CURL CURL NORTH PUBLIC SCHOOL REDEVELOPMENT (SSD 17_8310) - RESPONSE TO SUBMISSIONS

This Response to Submissions letter (RtS) has been prepared on behalf of the NSW Department of Education (DoE) to respond to the submissions received during the public exhibition of an amended design for Curl Curl North Public School (SSD 16_8310).

2 PROPOSED SITE PLAN
1 : 500

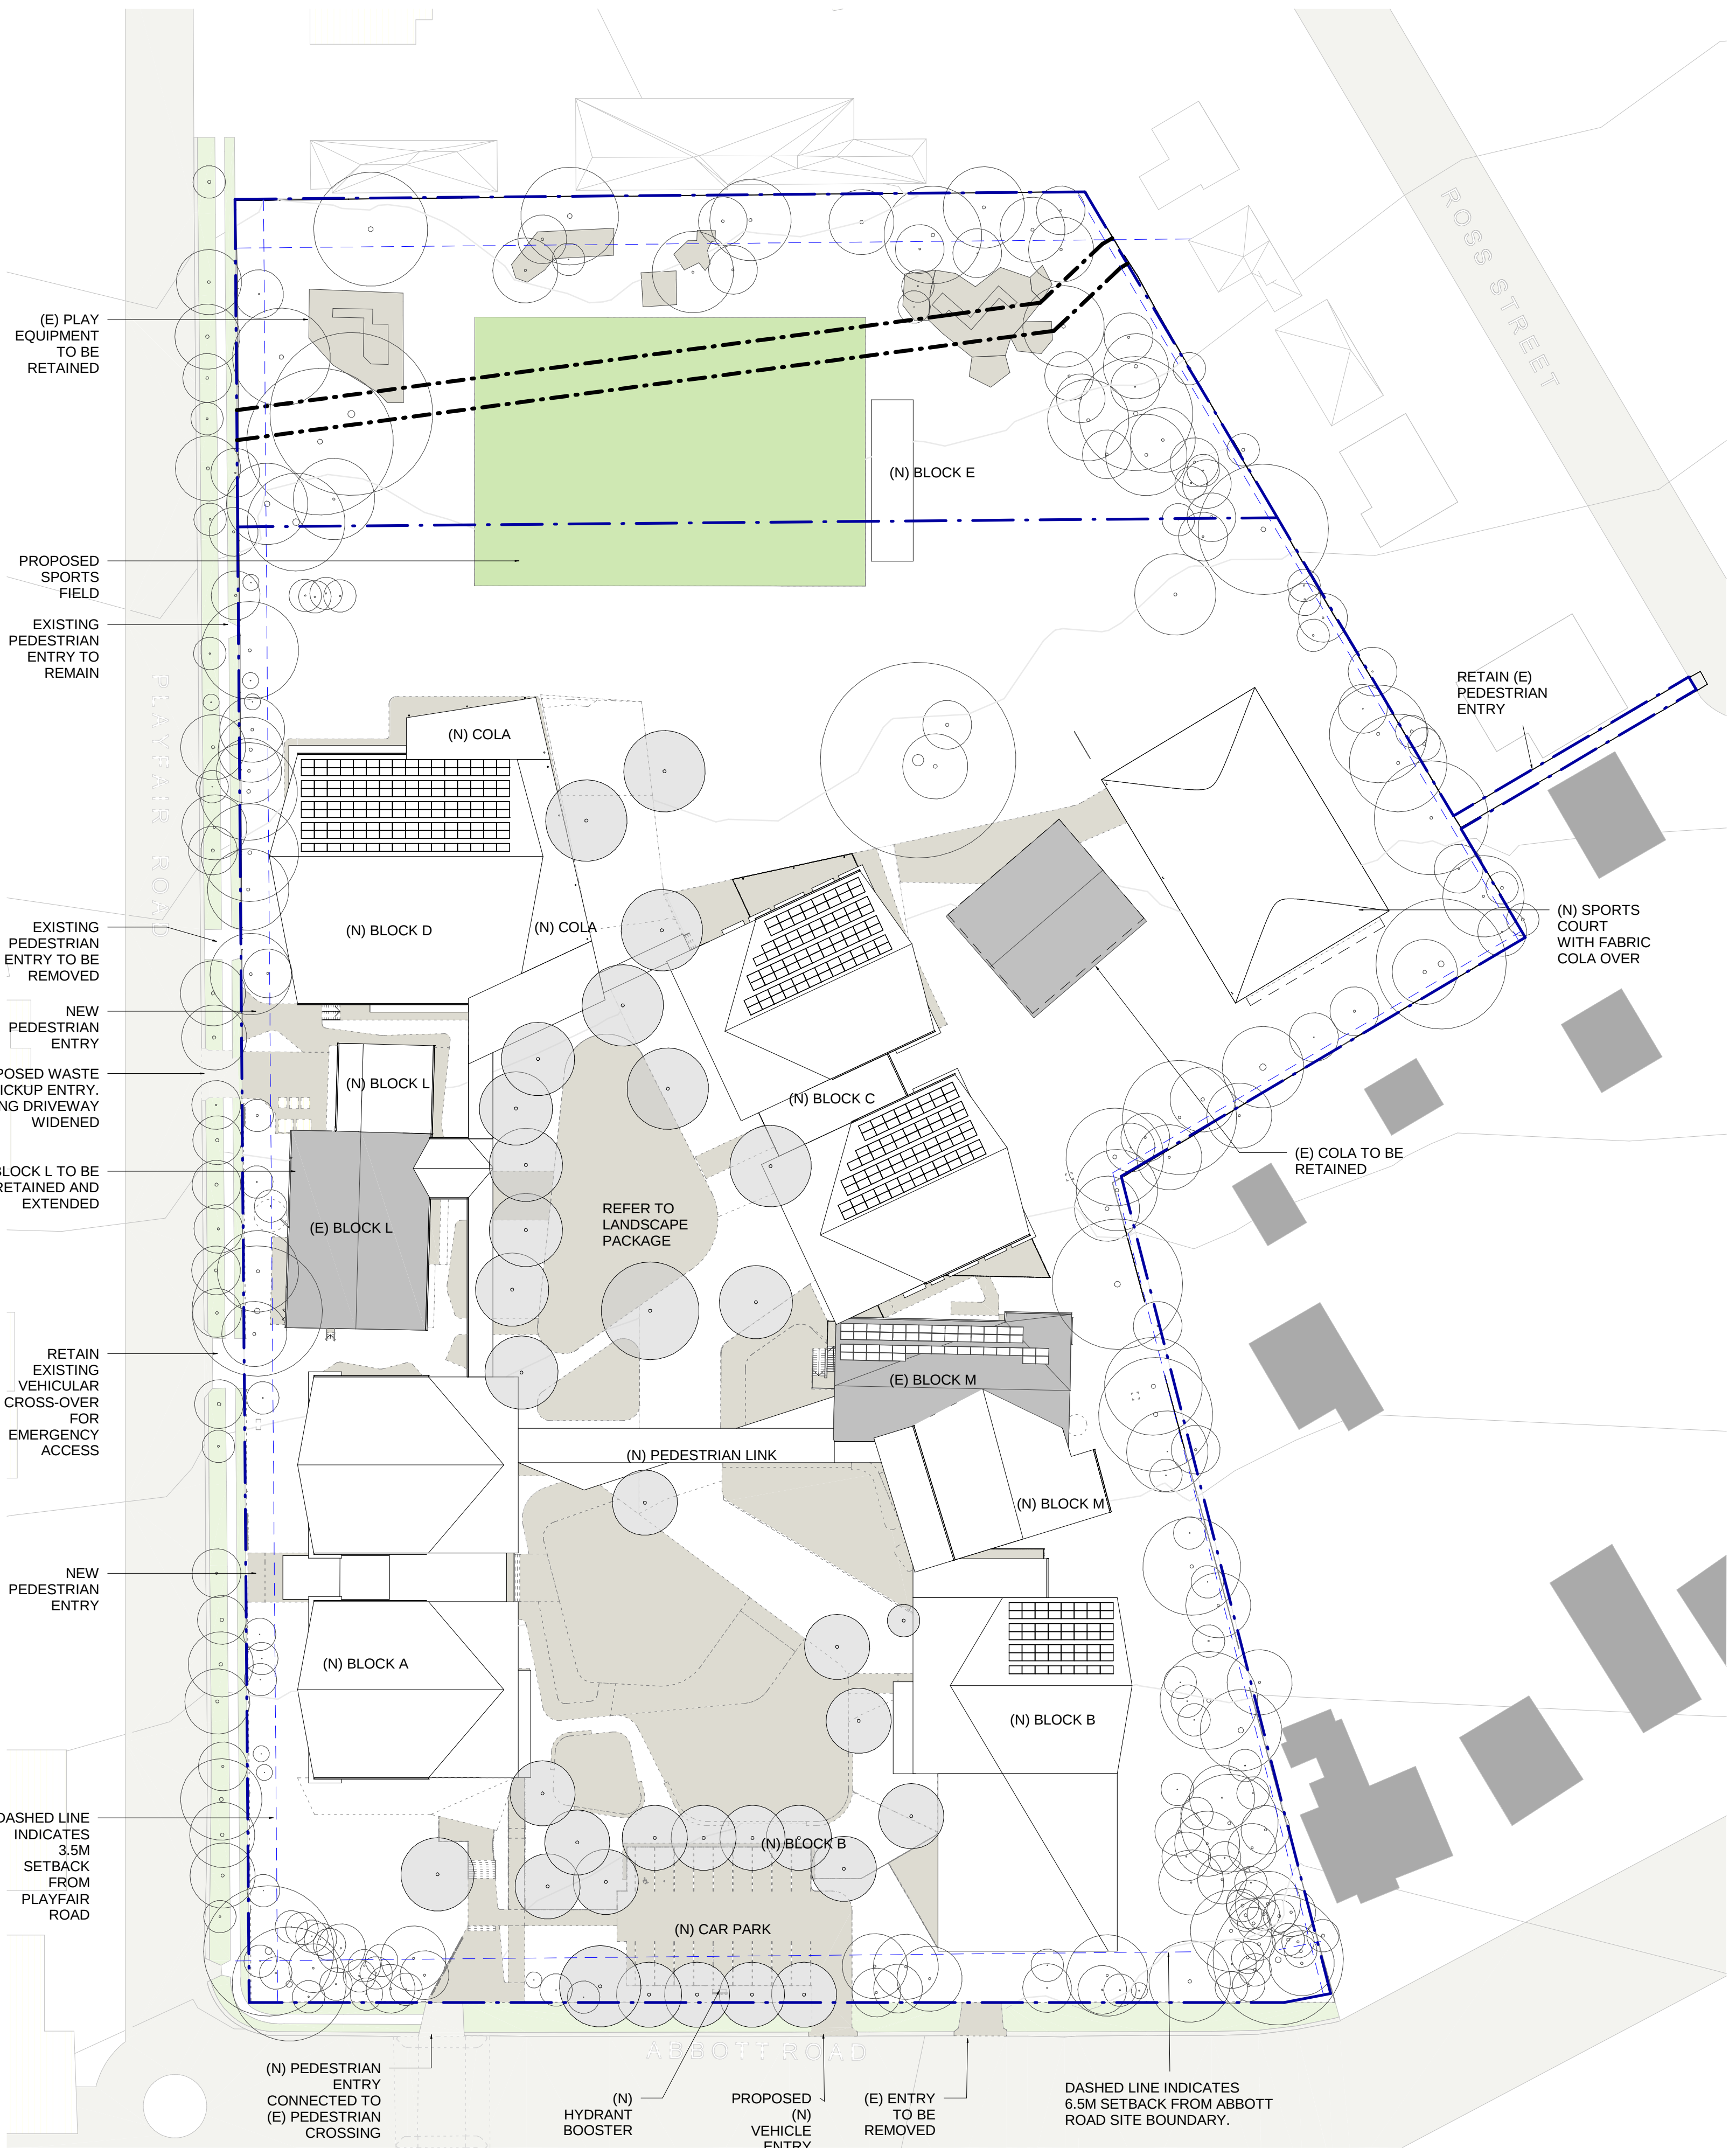
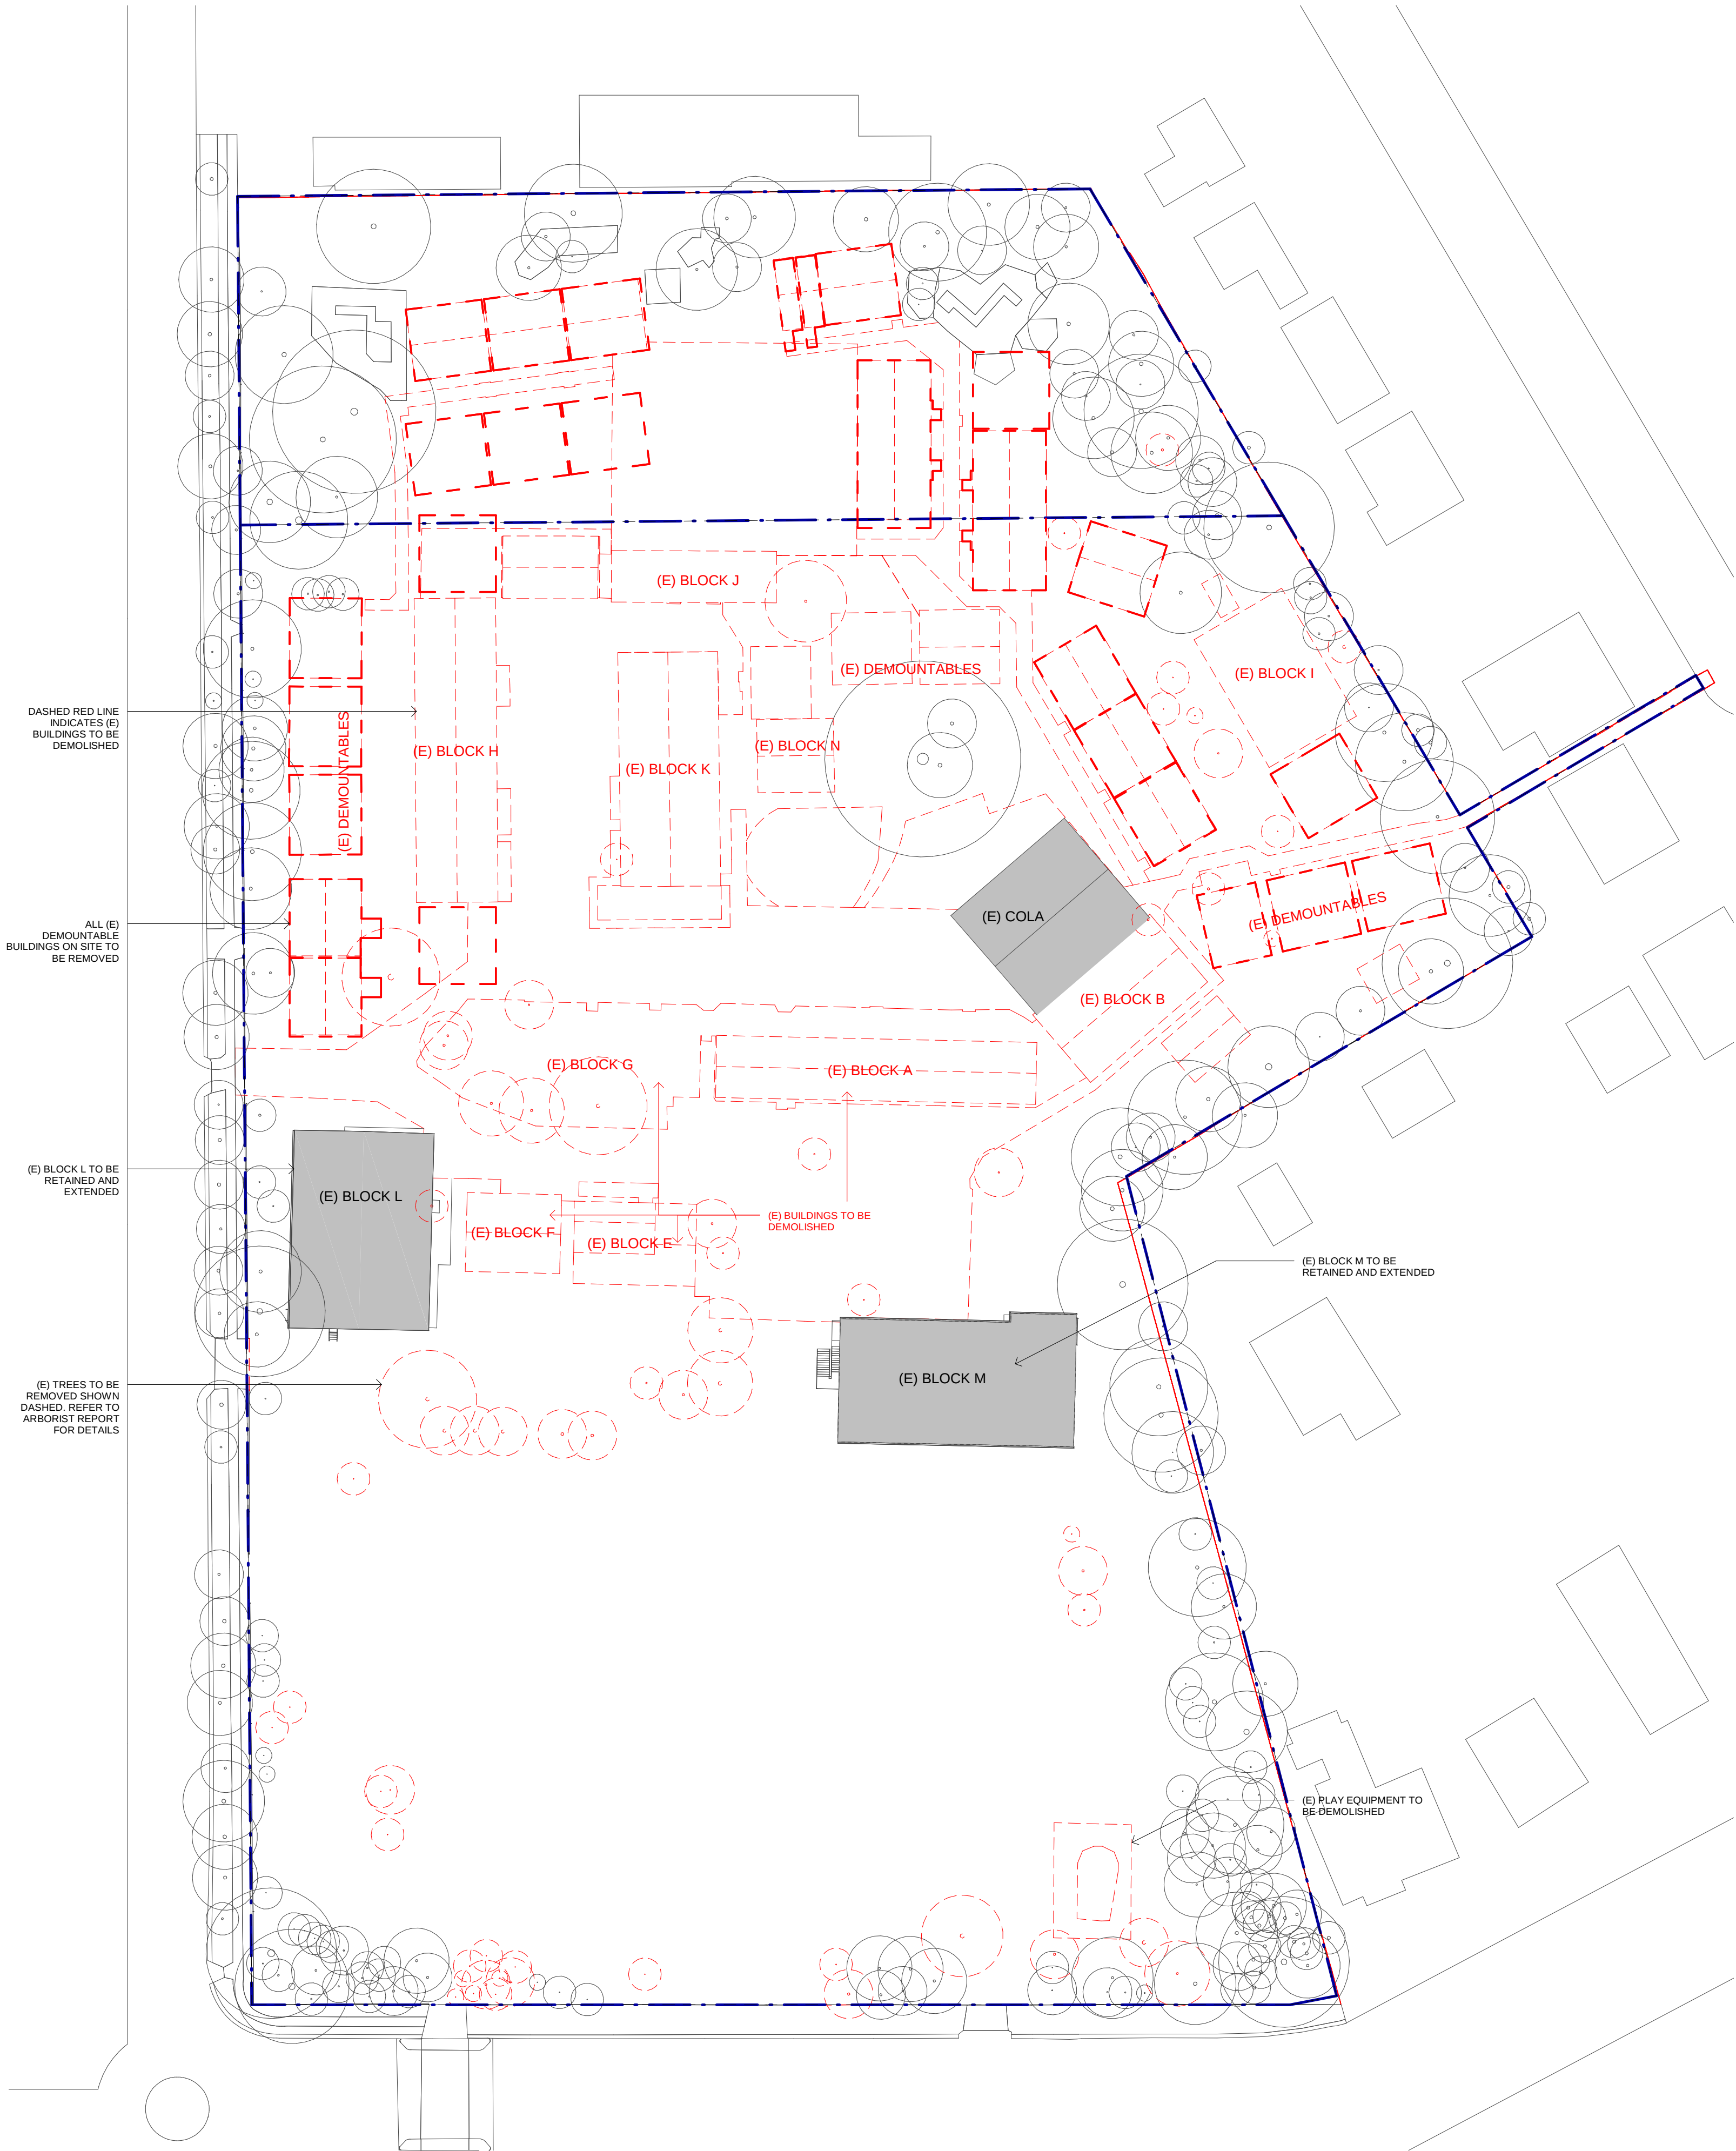
Issue	Comment	Response	Reference
NSW Department of Planning and Environment:			
1. Car Parking	• The proposal includes 16 car spaces which results in a reduction of 4 car spaces when compared to the existing situation. The proposal however seeks approval for an increase of 6 staff members. The documents do not provide any reason as to why the number of spaces has been reduced on site. There is space within the front setback to accommodate additional parking without impacting on the play areas.	• The proposal has been amended to now incorporate a total of 21 on-site car parking spaces. This is considered acceptable as: – The proposal maintains the existing number of car parking spaces; – Nearby parking that adjoins the Abbott Road Sports Grounds and Curl Curl Sports Centre (see Figure 1) has recently been upgraded to now include dedicated marked parking spaces. A high percentage of these spaces are free during school hours and can be utilised by school staff when required; – The proposal only results in a total increase of 6 staff only; – The car parking rates provided within the WDCP are not to be relied upon as: ▪ The WDCP is not a statutory requirement as specified by the project SEARs; and ▪ The Education Facilities Standards and Guidelines (EFSG) which are relied upon when designing schools within NSW states that on-site school	• Refer to amended Architectural Plans at Appendix A.

4. Car Parking	• 76 staff car parking spaces should be provided in compliance with the Council requirements. • It is recommended that additional parking be incorporated adjacent to the eastern side of building Block B where up to at least 20 additional parking spaces could be accommodated while still maintaining an acceptable landscaped buffer with the adjoining property.	• See car parking comments provided for issue 1 within Table 1 of this RtS letter. • Additional car parking spaces cannot be provided adjacent to the eastern side of building Block B as: – It is considered a potential hazard to allow cars to be parked in close proximity to multiple homebase buildings; – This area of the site contains a significant number of established trees that would need to be removed to facilitate parking in this area; and	• Refer to issue 1 within Table 1 of this RtS letter.
